PLANNING CONSULTATION RESPONSE

Application No	2025/0583
Proposal	Erection of detached two-storey dwelling with associated access and garage.
Address	Land adjacent St John the Evangelist Church, Carlton Road, Carlton, Barnsley.
Date of Consultation Reply	04/09/2025
Consultee	Katie Lawrence, Planning Ecologist

NORTH ELEVATION

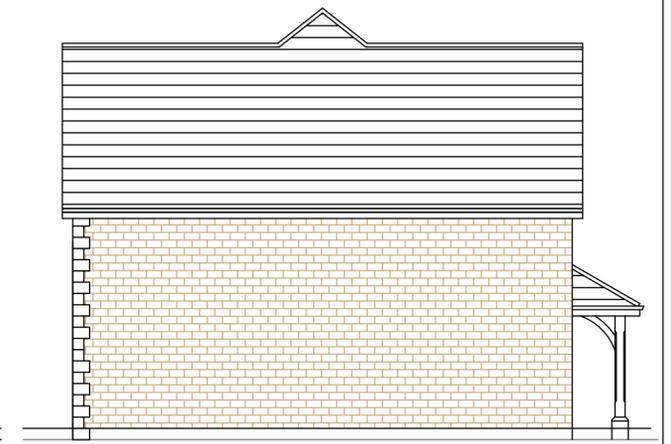
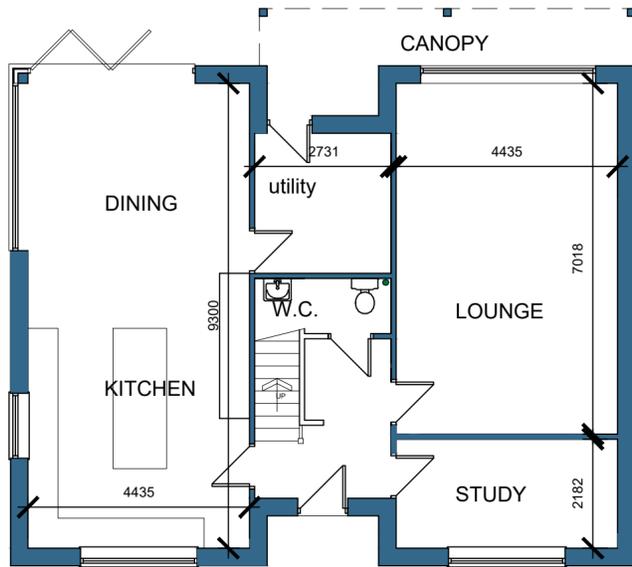
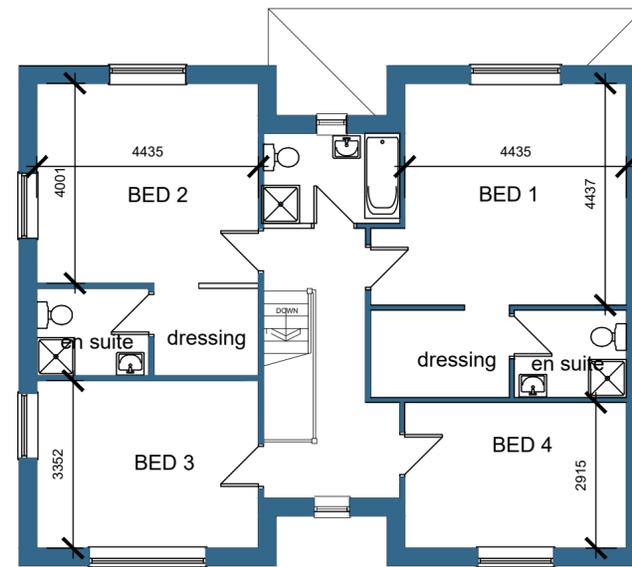
- The drawing titled plans and elevations includes proposed locations for a bat, swift and bee box on the proposed building and hedgehog access points within the boundary fencing, which is welcomed. The swift brick would ideally be located on the north or east elevation. If this can be amended these measures can be secured by a planning condition.
